Recommendation Report for Planning Permission for Works or Extension to a Dwelling

REF NO: AL/101/24/HH

LOCATION: The Bungalow
Nyton Road
Westergate
PO20 3UQ

PROPOSAL: Single storey front porch and rear extension, conversion of integral garage to habitable use, extension to detached garage and alterations to fenestration/openings.

CLIENT	MR & MRS K. THOMAS					
DRAWING TITLE						
PROPOSED PORCH, GARAGE CONVERSION & GARAGE EXTENSION THE BUNGALOW, NYTON ROAD WESTERGATE WEST SUSSEX PO20 3UQ						
CHECKED	DATE	SCALE	DRAWN			
JGM	AUG-24	1:50 mm	JGM			
PROJECT / DRAWING No.			REV			
003			0

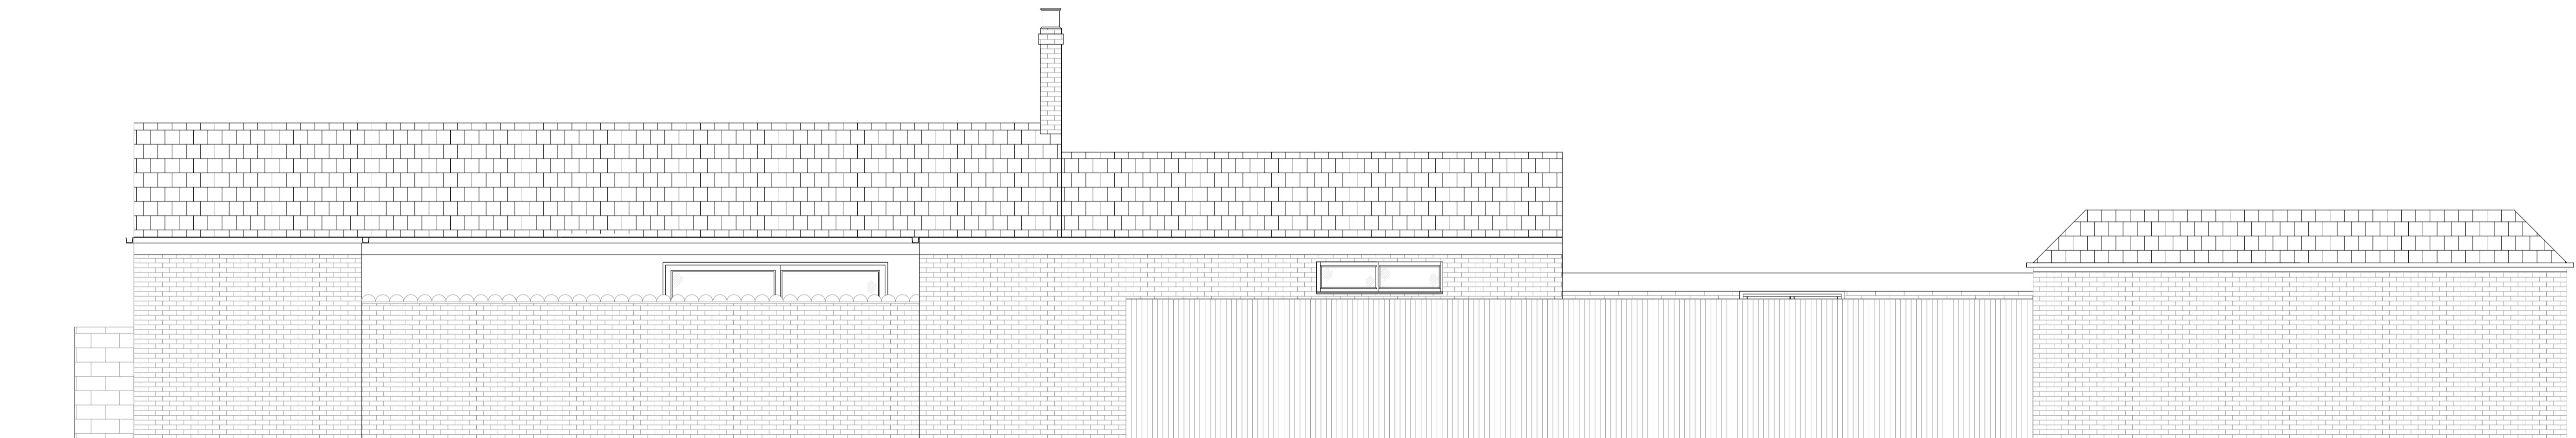
Multiple alterations are proposed to the fenestration of the existing dwelling. Giving the siting, the fenestration changes proposed to the front (south) elevation would not result in any overlooking effects. No additional fenestration is proposed to the north (rear) elevation. The garage door to the north elevation of the detached garage would be removed and replaced with new garage door to the south elevation of the extended detached garage.

CLIENT	MR & MRS K. THOMAS		
DRAWING TITLE	PROPOSED PORCH, GARAGE CONVERSION & GARAGE EXTENSION THE BUNGALOW, NYTON ROAD WESTERGATE WEST SUSSEX PO20 3UQ		
SCALE	500	DATE	AUG-24
DRAWN	JGM	REVISION	0
CHECKED		PROJECT / DRAWING No.	004
DATE		DRAWN	JGM
SCALE		REVISION	0

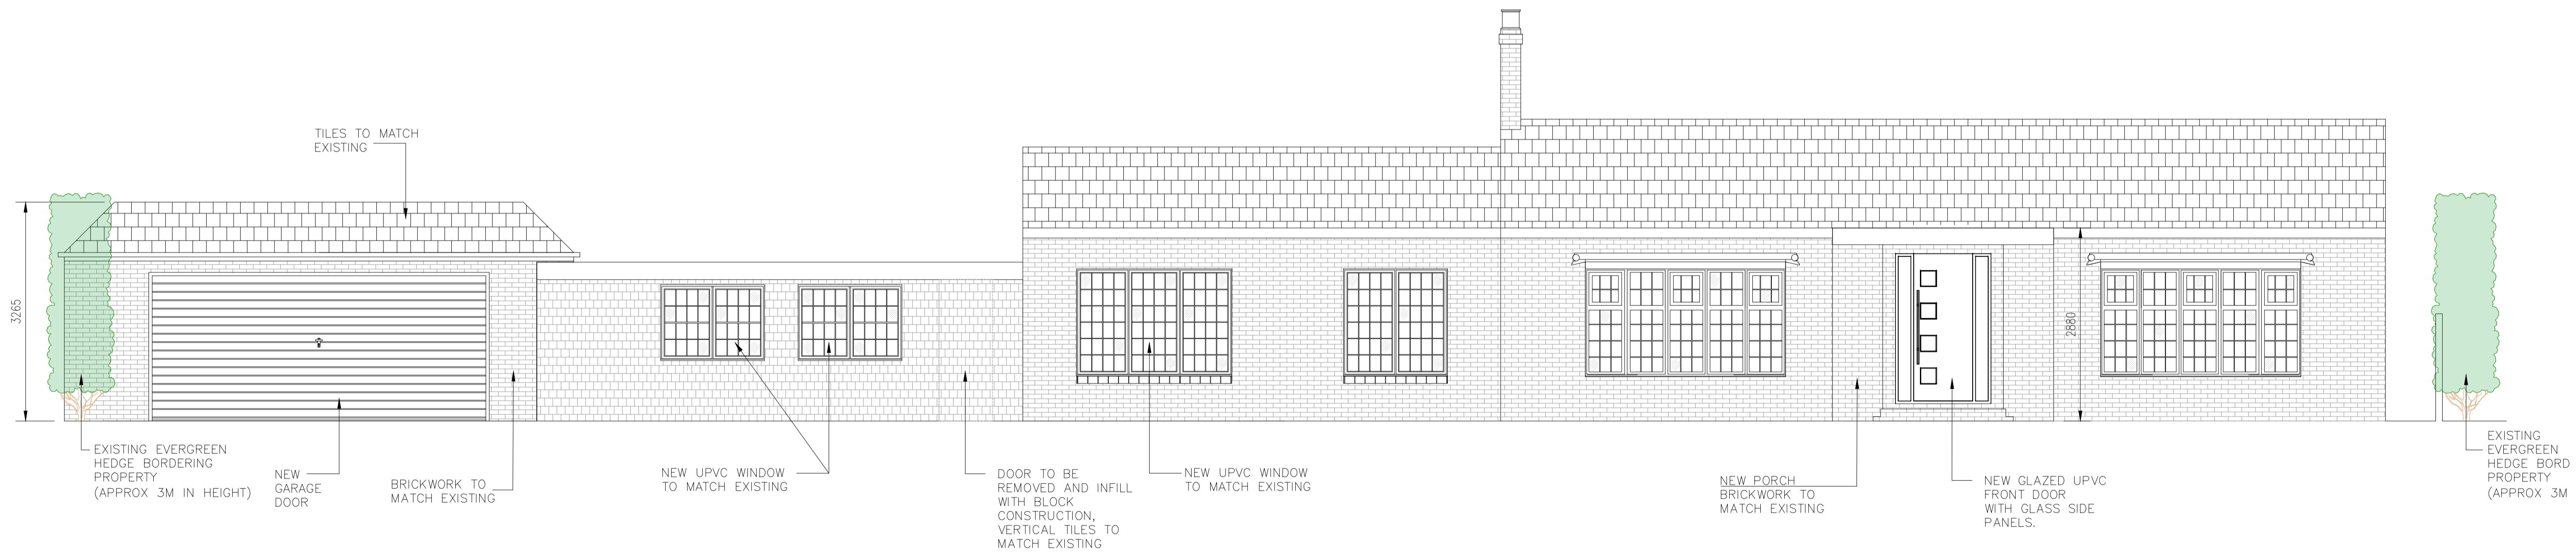
The front extension is a small-scale extension that would replace an existing 1.8m by 1.7m front porch. The proposed front extension would measure 3.3m in width by 1.7m in depth and would be a minor alteration to the front elevation of the dwelling. Given the scale of works proposed and that the extension would be a replacement of an existing structure, the proposed porch would not result in any harm to the character of the dwelling or surrounding area. This extension would have a flat roof design with a skylight and the proposed materials would match the existing dwelling.

It is stated in the Arun Design Guide (ADG) that front extensions should take care not to disrupt the existing composition of the street in terms of rhythm or building line and ensure continuation of existing building design in terms of details and materials. Front extensions should be no deeper than 1.5m. Whilst it is noted that the front porch would exceed the guidance, with a depth of 1.7m, it is noted that the difference would be minimal, and given the curved nature of the porch, the depth is acceptable in this instance. Furthermore, the street scene of Nyton Road is varied in nature and therefore the replacement porch is acceptable.
